From: FRS Water and Access [REDACTED]
Sent: 22 December 2022 12:46
To: Planning.Responses <Planning.Responses@arun.gov.uk>
Subject: Planning condition - BN/17/21/PL The Cottage Highground Lane Barnham PO22 0BT

I have had several conversations with Mr Akmenkalns regarding the condition raised for the re-build of this property. Mr Akmenkalns explained that refuse lorries and Travis Perkins delivery lorries can gain access to the site, turn and make their exit and the fact that the access road is wider than indicated on our mapping. Our rule is generally if a refuse collection lorry can gain access, turn and make an exit then a fire appliance will also be capable of the same. So I am satisfied a fire appliance can gain access to the property.

SITE / BLOCK PLAN 1:500

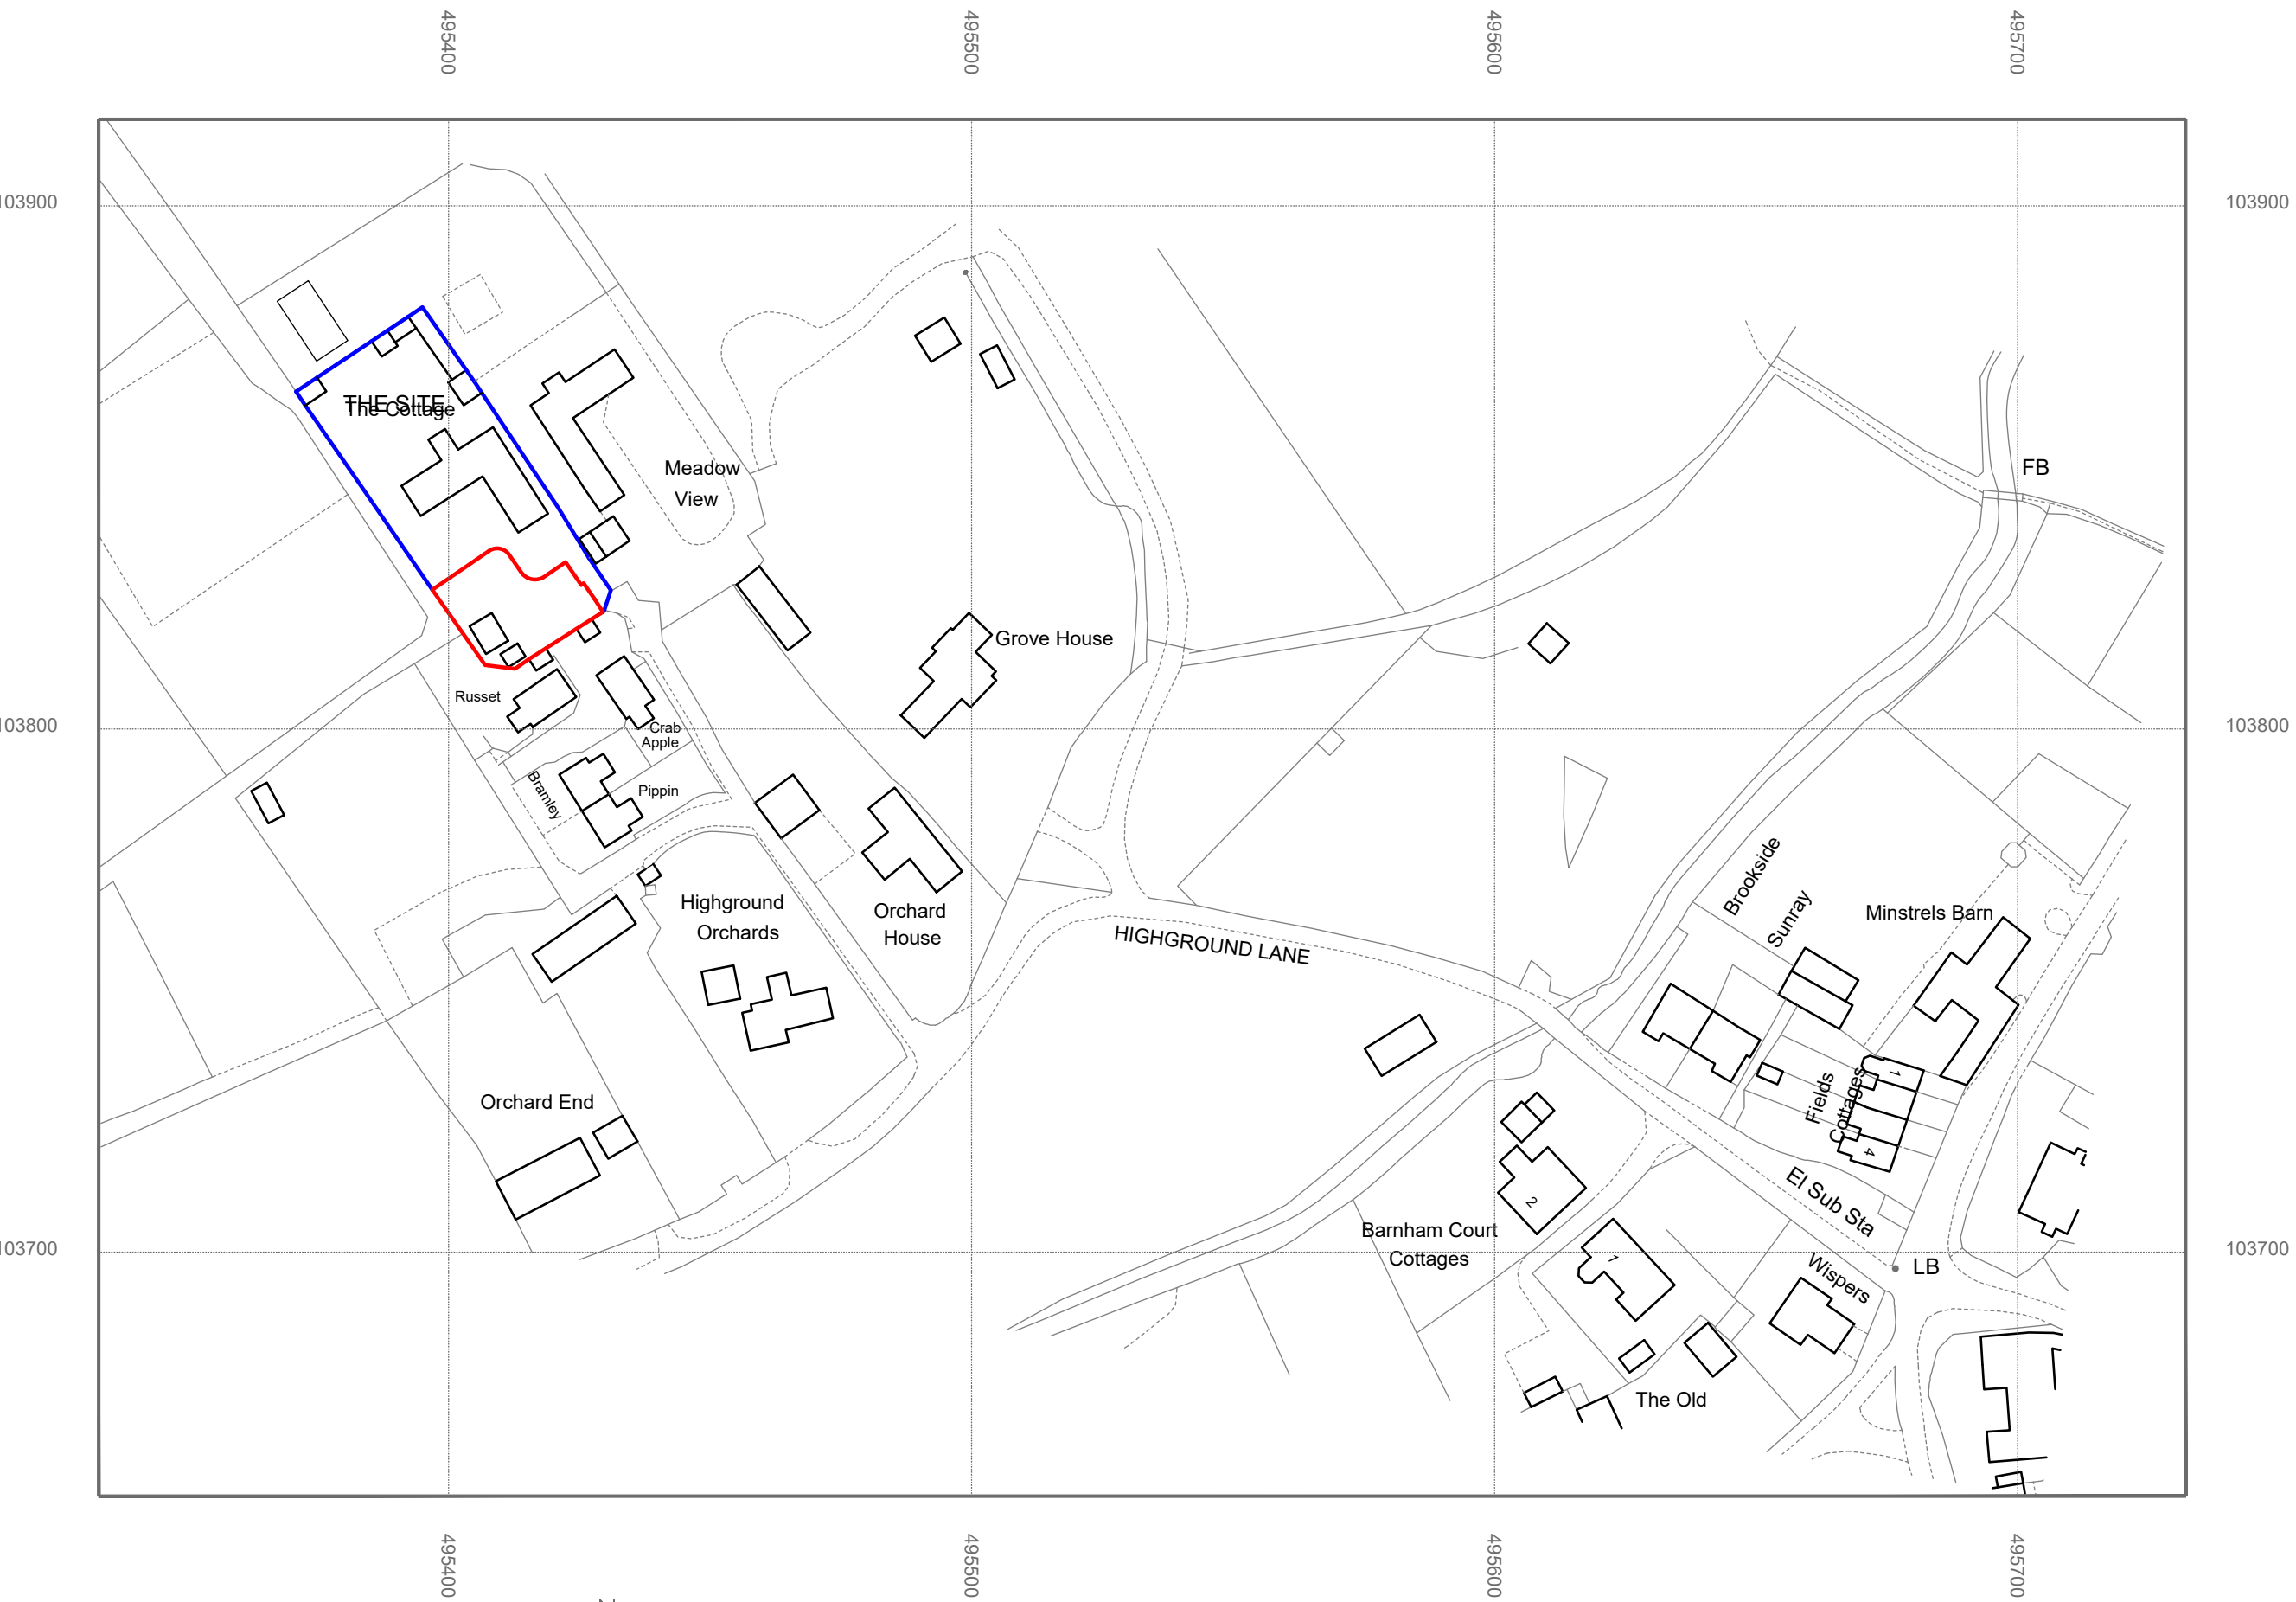
With regards to the supply of water for firefighting, the nearest fire hydrant is 385m away, however Mr Akmenkalns has informed me he has a swimming pool 45ft. x 26ft. x 6.6ft. Which would hold approximately 340,000 litres of water and meet the requirements of an alternative water supply identified in AD-B Volume 1 B5 section 14. So again this would meet with the alternative supply of water for firefighting and meet with the condition raised.

I am satisfied the requirements of the condition raised have been met and it can now be discharged.
